# Consultee Comments for Application 2025/91529

Application Number: 2025/91731

Address: land off Bankfield Drive, Holmbridge, Holmfirth, HD9 2PH

Proposal: Discharge of details reserved by conditions 12 (pedestrian connection), 13 (cycle parking), 15 (collection of wastes), 21 (Remediation Strategy), 23 (external materials), 24 (windows and doors), 25 (electricity substations), 26 (boundary treatments), 27 (external lighting) on previous permission 2023/91212 for erection of 21 dwellings with access from Laithe Avenue

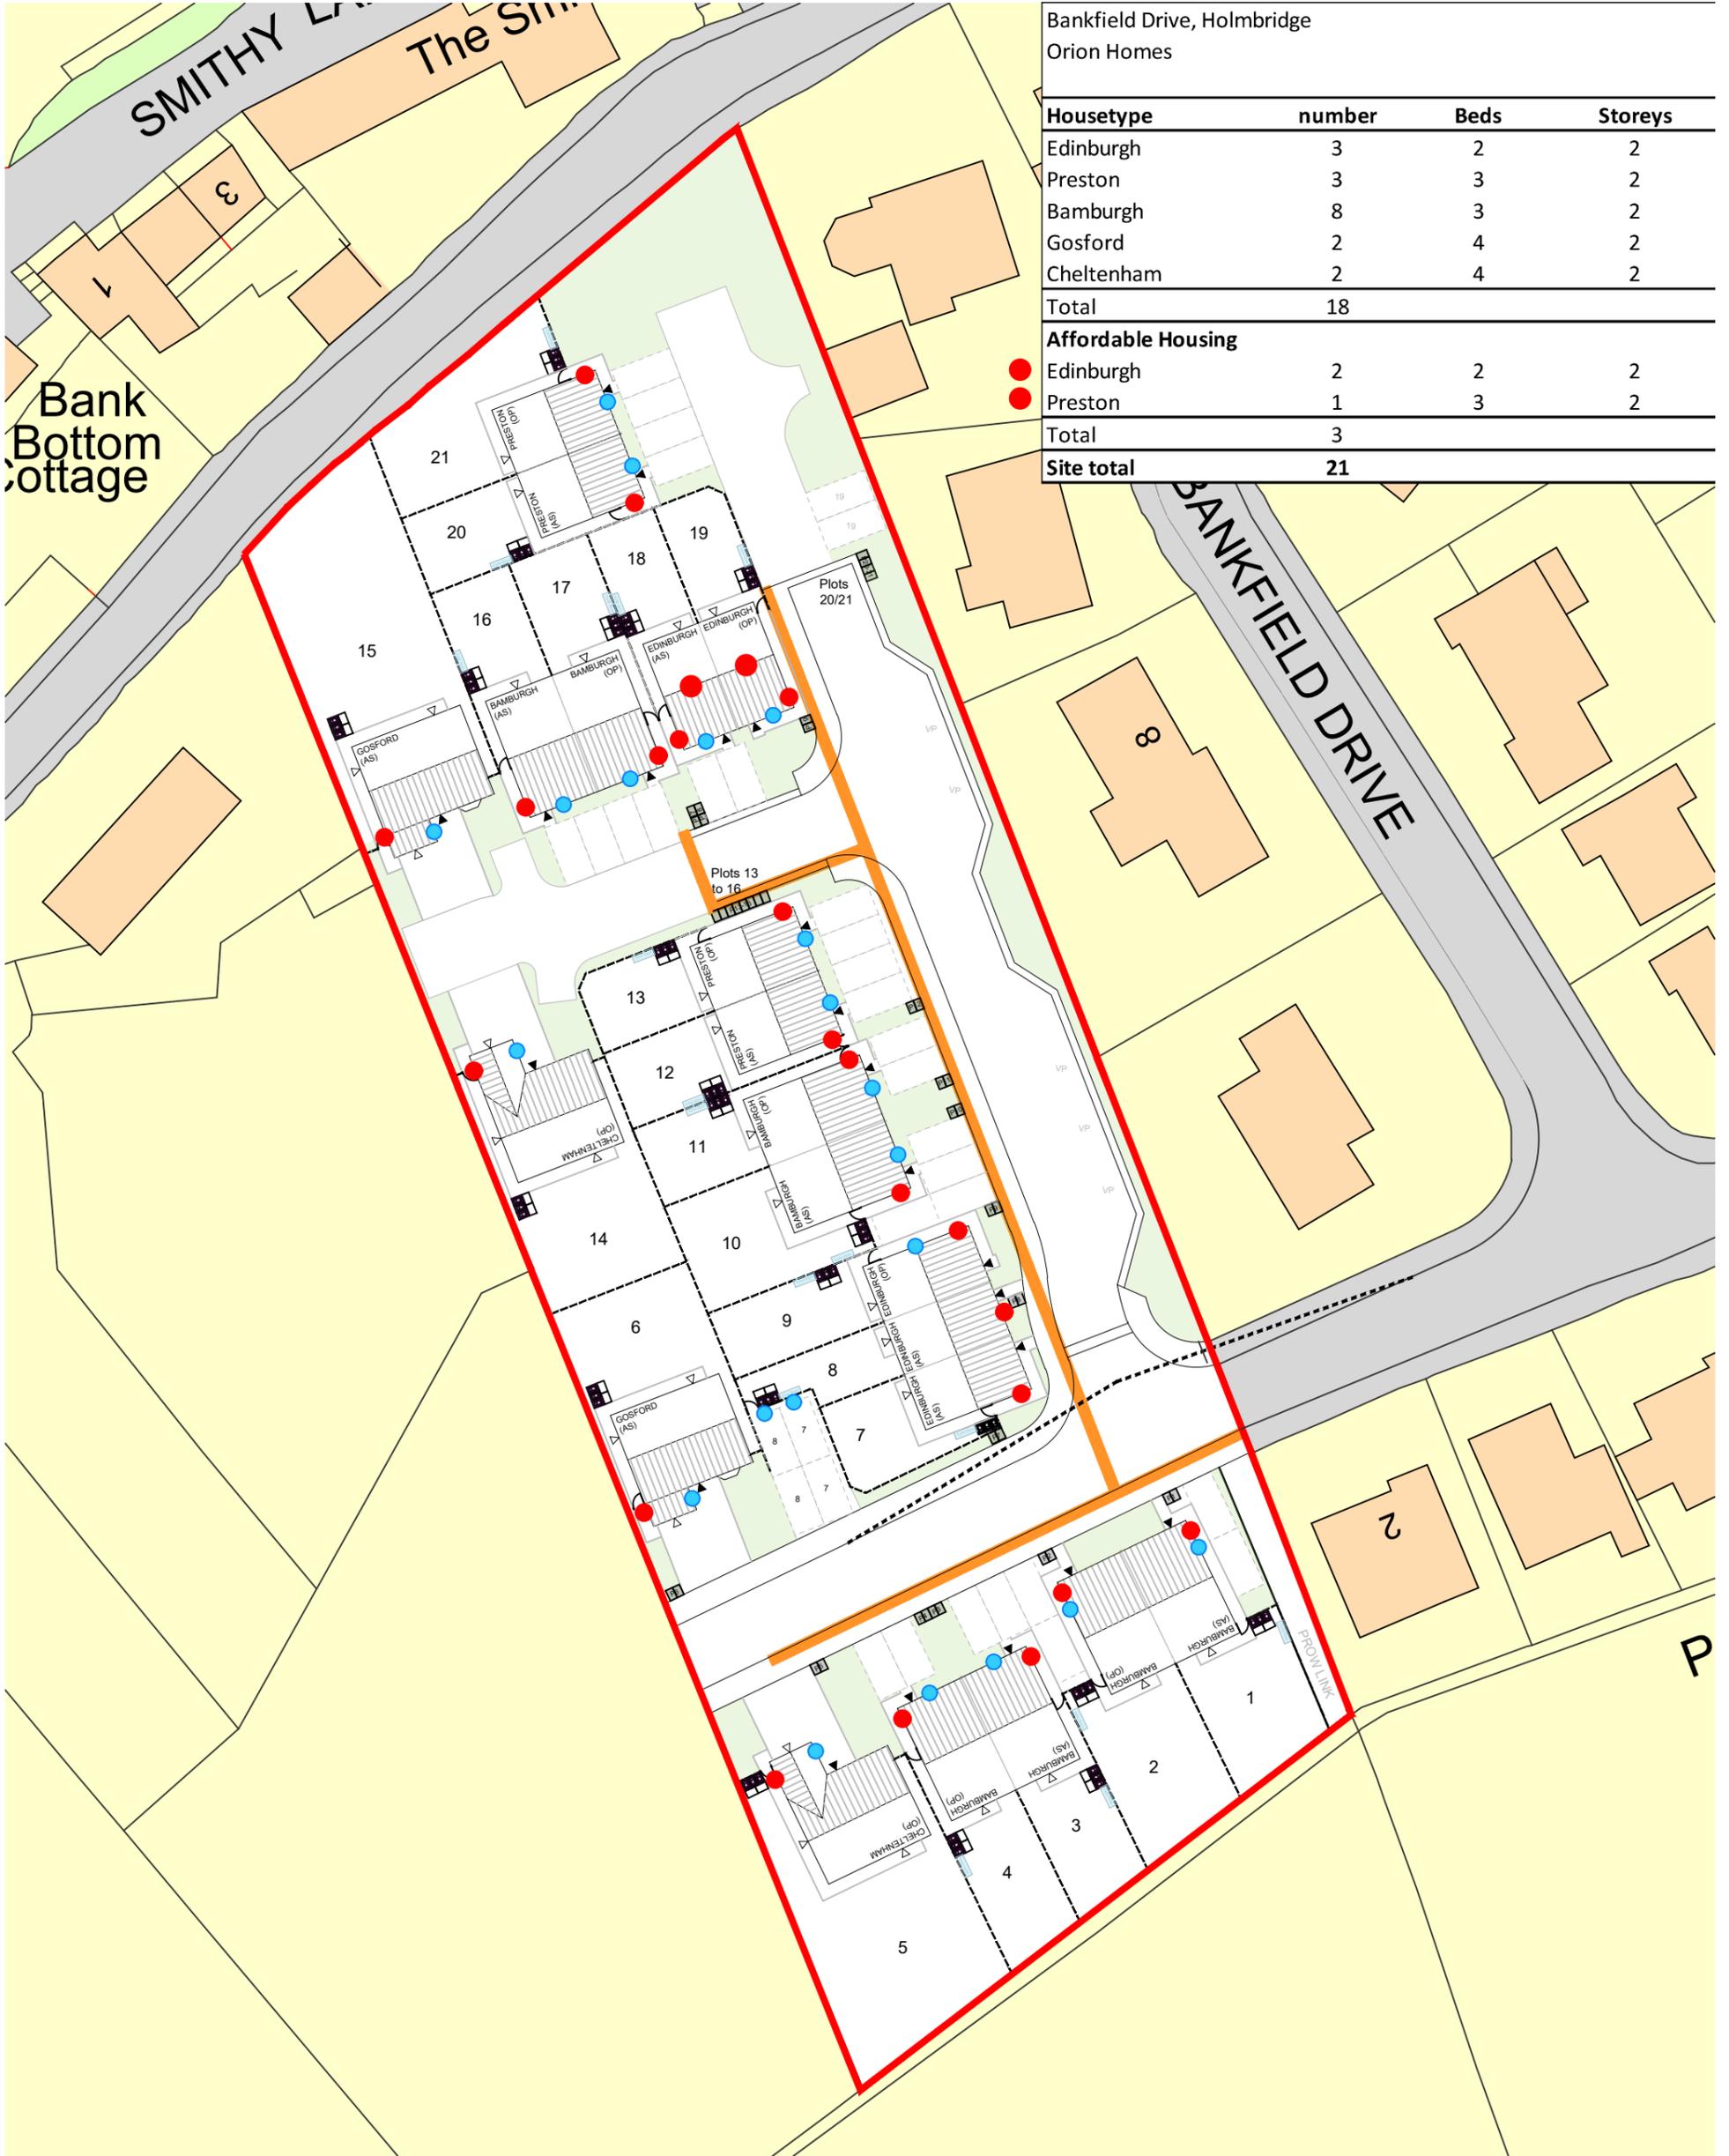
Can more details be provided in relation to the fence and gate design, please.

The gates should match the design and height of the fence, and be lockable (latch on the outside, bolt on the inside as there are no parking spaces located within the fenced-off areas). The fence should have a smooth outward face with no cross members or footholds to deter climbing.

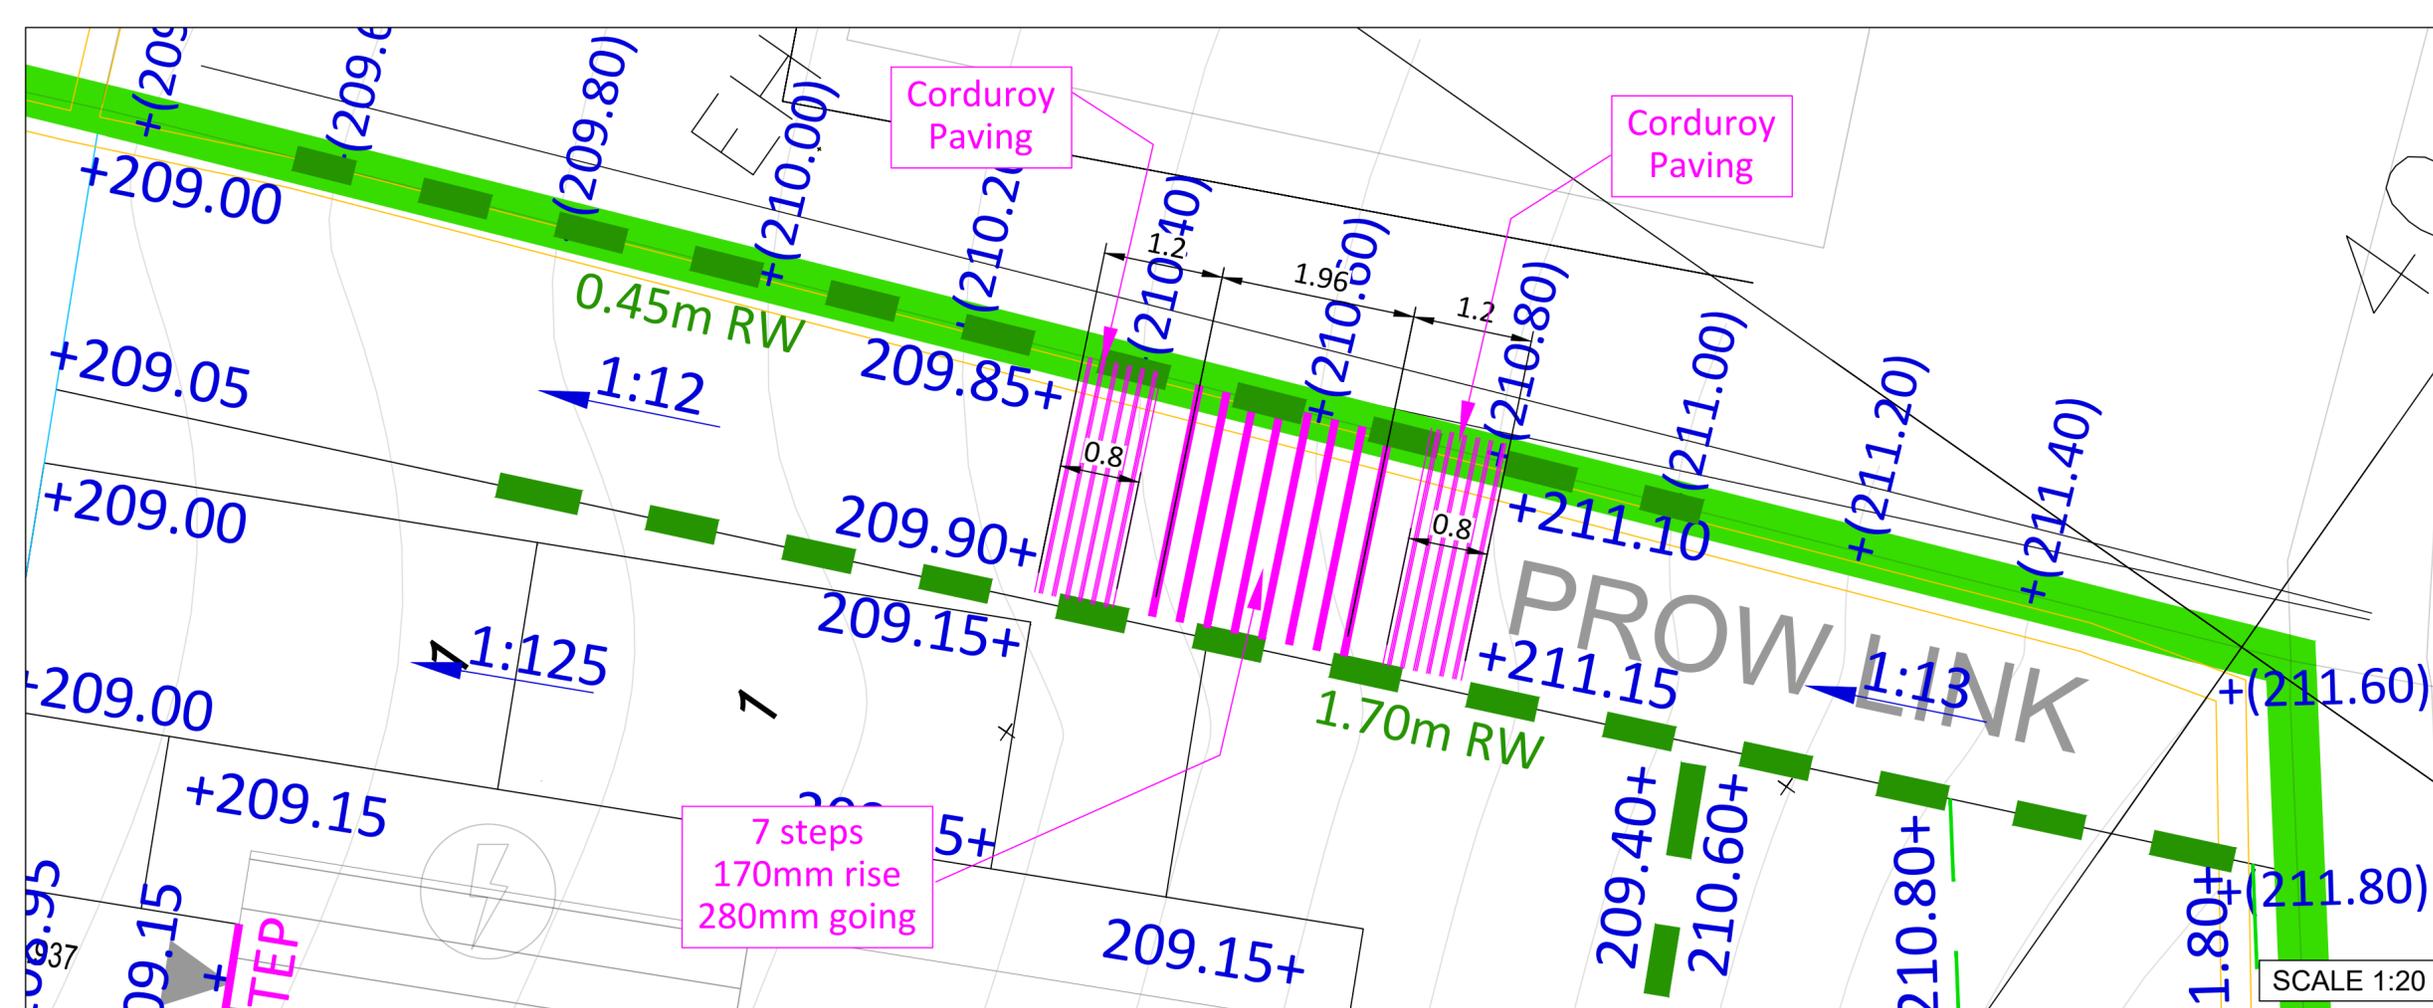
No issues with the layout. Can the applicant confirm if lighting will be provided in this area, as a safety measure.
